Your Ref: OWPC15654
Our Ref: R/184/17/PD 08-08-2017
Please ask for:
Mrs A Gardner

Notification for prior approval under class C for a change of use from a shop (Class A1)
to a restaurant/cafe (Class A3)
51 Sea Lane Rustington

**APPENDIX ONE:
DRAWING SHOWING EXTERNAL EXTRACT AND VENTILATION EQUIPMENT PROPOSED**

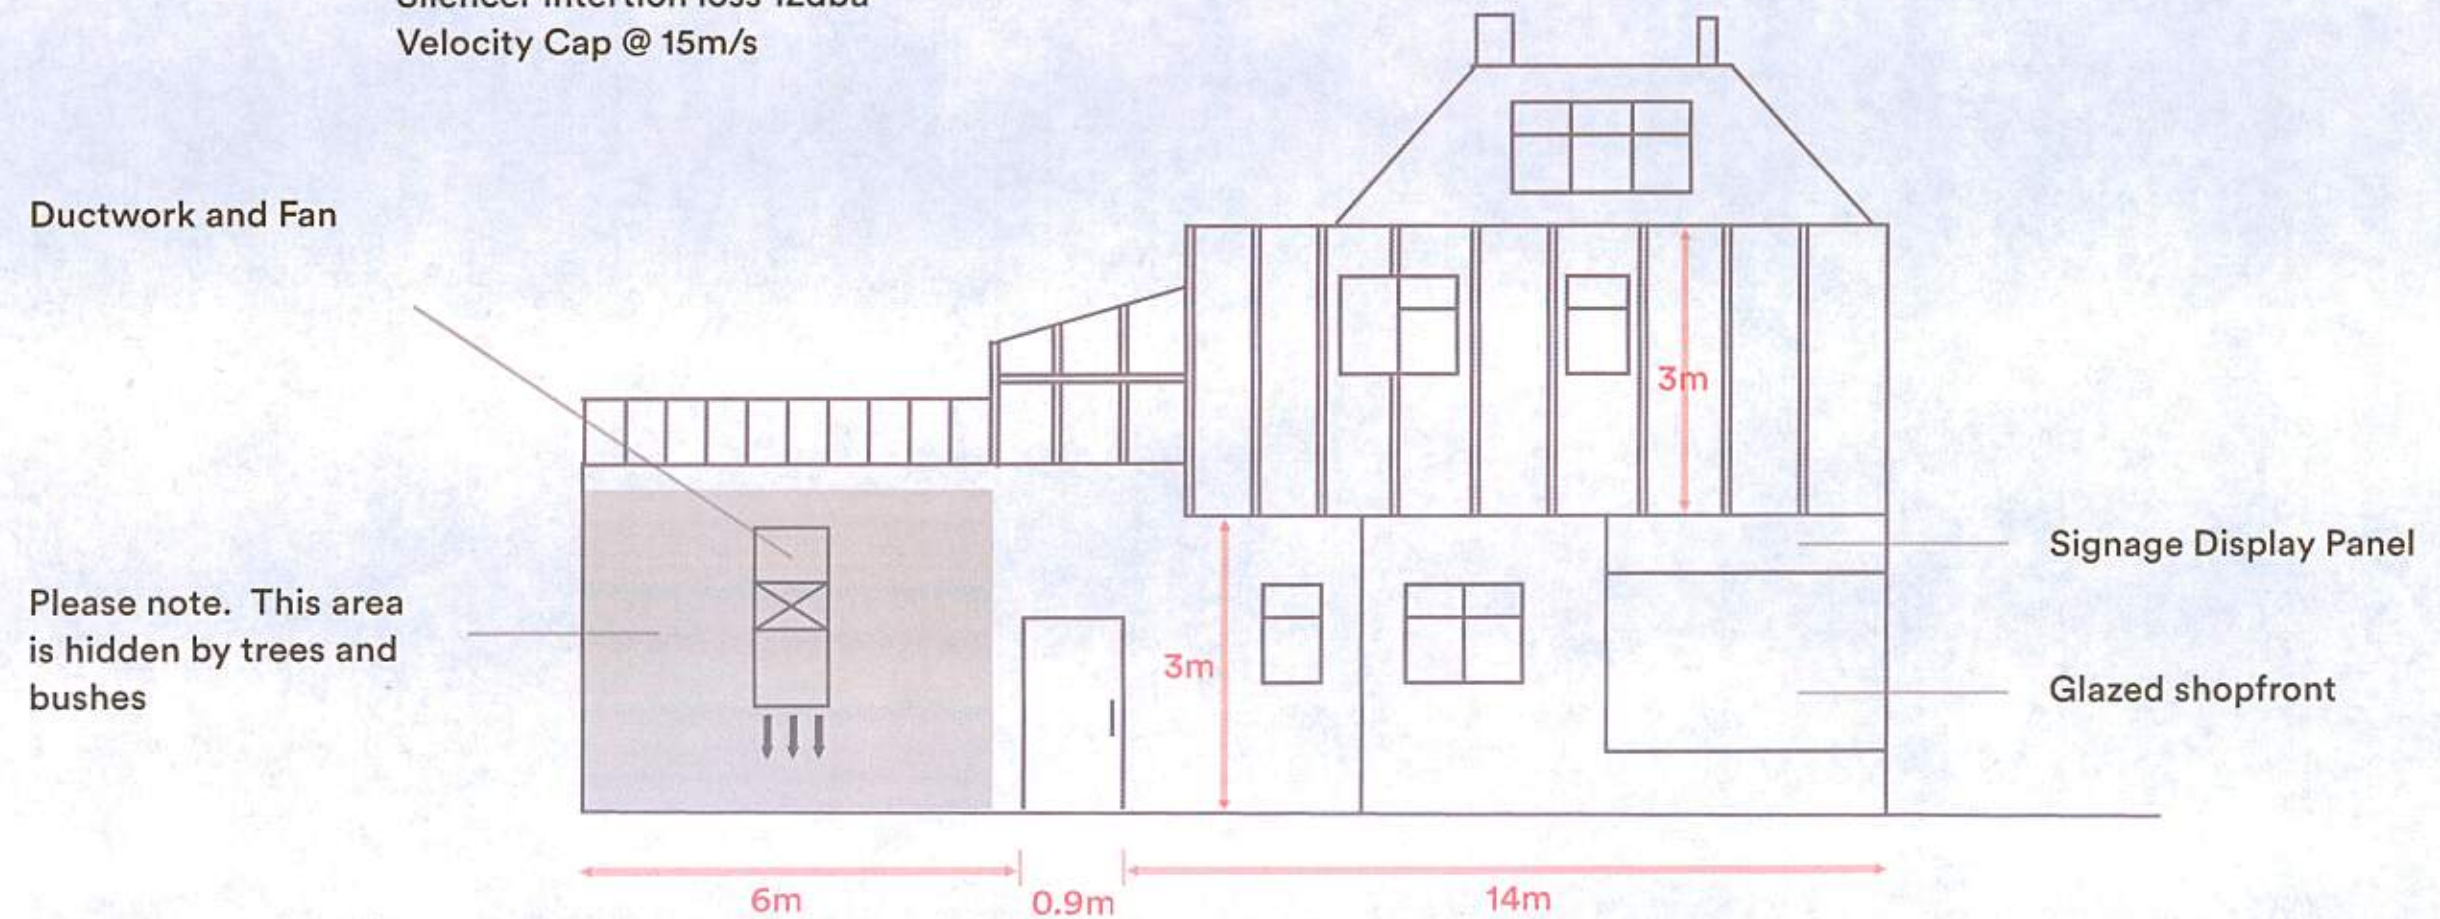
I also concerned at the potential of the constant smell from any cooking that will take place as Cudlow avenue is in the path of the prevailing wind direction.
